REQUEST

Current Zoning: R-8 (single family residential)
Proposed Zoning: UR-1(CD) (urban residential, conditional) & UR-C (CD) (urban residential commercial, conditional)

Approximately .17 acres located at the eastern corner of N. Davidson Street and E. 19th Street in the Optimist Park community.

The petition proposes to rezone to two urban residential districts in order to allow for the construction of two attached dwelling units on the back side of the property at an approximate density of 22.2 DUA while preserving the historic storefront for specific uses allowed in the UR-C zoning district as noted in the conditional plan.

PROPOSED SITE PLAN
A-1.1
OF: TWO

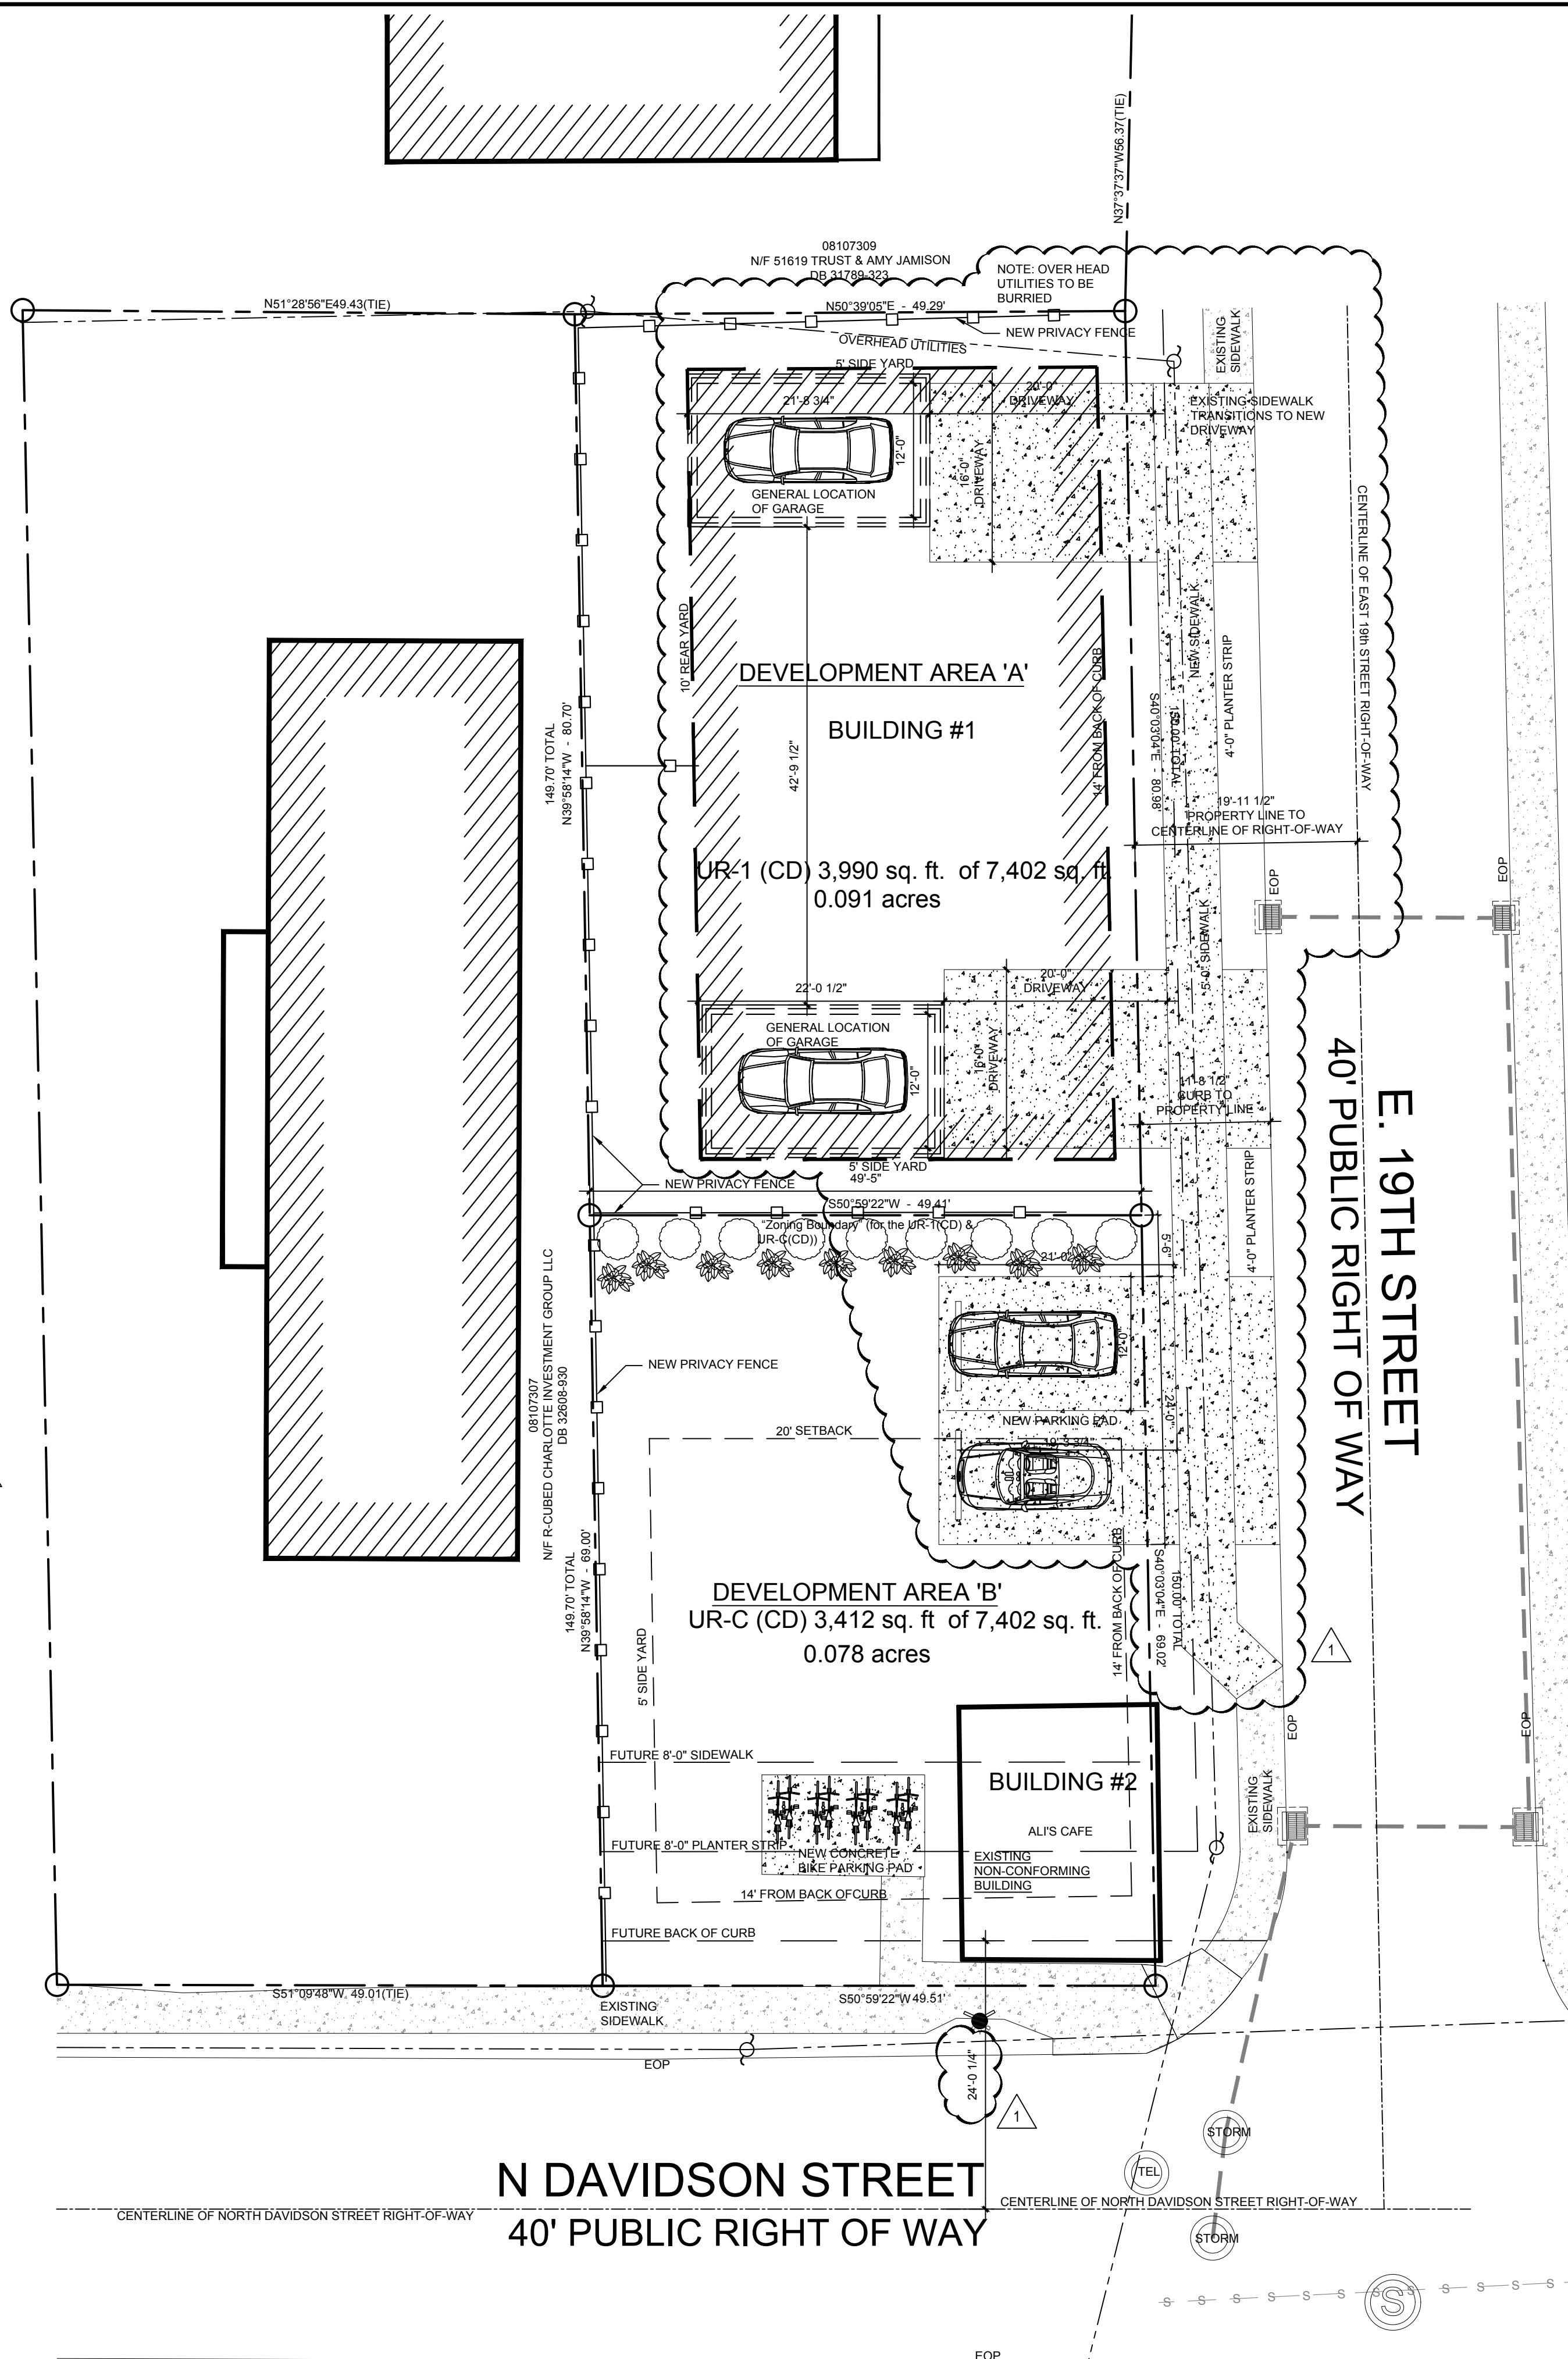
- ~~1. Revise the northern portion of the rezoning boundary (the portion requesting UR-1 designation) into a bubble diagram illustrating buildable footprint only. **ADDRESSED**~~

- ~~2. CDOT is requesting the petitioner update the site plan and conditional notes to show and dimension an 8-foot planting strip and 5-foot sidewalk along 19th Street. **ADDRESSED**~~
- ~~3. The petitioner should revise the site plan to add a note specifying dedication and fee simple conveyance of all rights of way to the City before the site's first building certificate of occupancy is issued. CDOT requests right of way set at 2-foot behind the back of sidewalk where feasible. **ADDRESSED**~~
- ~~4. The future location of curb and gutter is 24' from centerline to back of curb. The site plan should show the curb and gutter labeled and dimensioned from the centerline of each road. **ADDRESSED**~~

- ~~5. In the notes table for Development Area B, revise note 3.D to reflect the commitment only and remove any wording that is reflective of the request to add the note. There is no phasing requested in the plan. **ADDRESSED**~~
- ~~6. Move note 1.F to the Transportation section of the notes; remove bolding and underline formatting. **ADDRESSED**~~
- ~~7. Remove note 3.C. **ADDRESSED**~~
